From: [Arden Thomas](#)
To: ["Dorrance Denner"](#); [Chace Pedersen](#); exofficiator@yahoo.com
Cc: [Toni Berkshire](#); [Samantha Cox](#)
Subject: RE: SX-22-00021 Sporar - Request for Additional Information / Incorrect property boundaries
Date: Wednesday, November 9, 2022 5:03:41 PM

Subject: SX-22-00021 Sporar - Request for Additional Information

<b>FEMA BASED ZONE MAP</b>		
PREPARED FOR <b>MR. TOM SPORAR</b>		
KITTITAS COUNTY,	DATE	RSN NO.
OWN BY <b>AGJ</b>	<b>12/07</b>	<b>07178</b>
DRAWN BY <b>R. BOGDON</b>	SCALE <b>1"=20'</b>	SHEET <b>1 of 1</b>

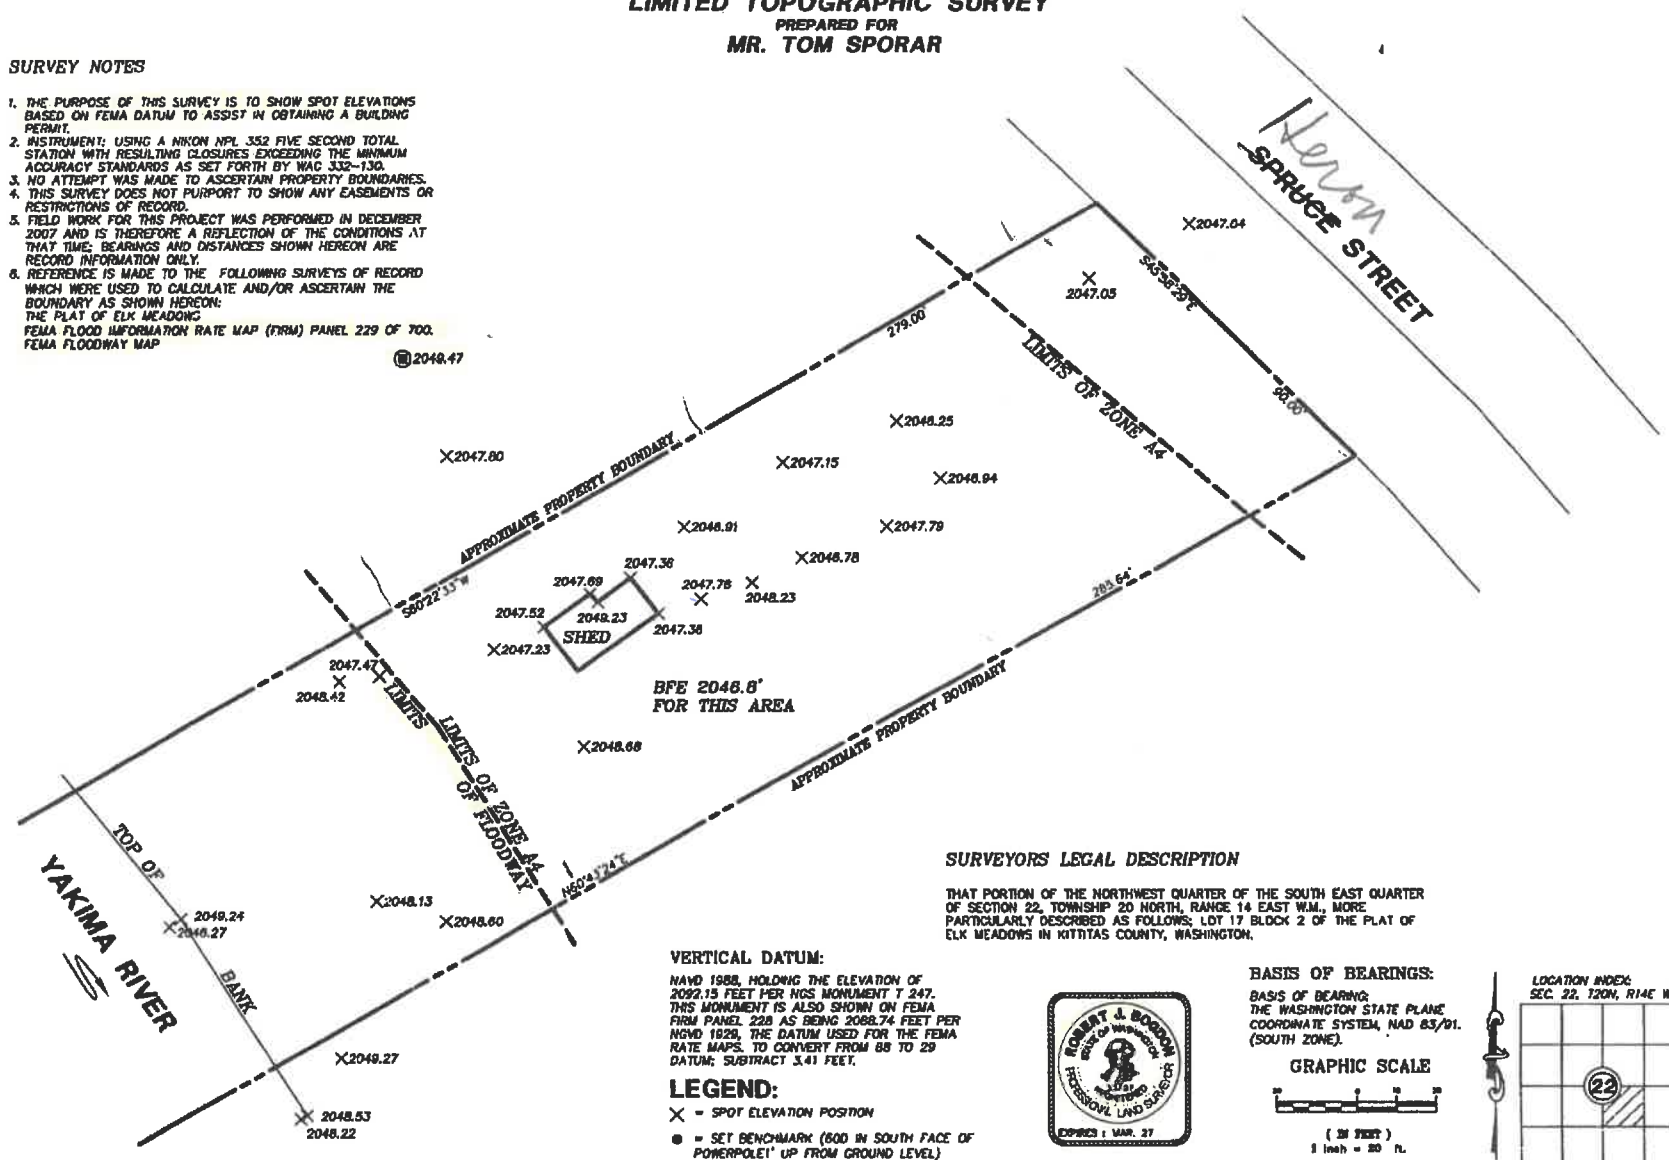
The floodway delineation survey will need to be redone and will need to be staked out on the property. The FEMA regulatory maps changed in 2021 and so a floodway survey based on the 2007 floodway is no longer valid. At this point it is moot because of the map update, but I also have concerns about the floodway extent represented in the 2007 survey and would have needed additional information to understand how it was determined.
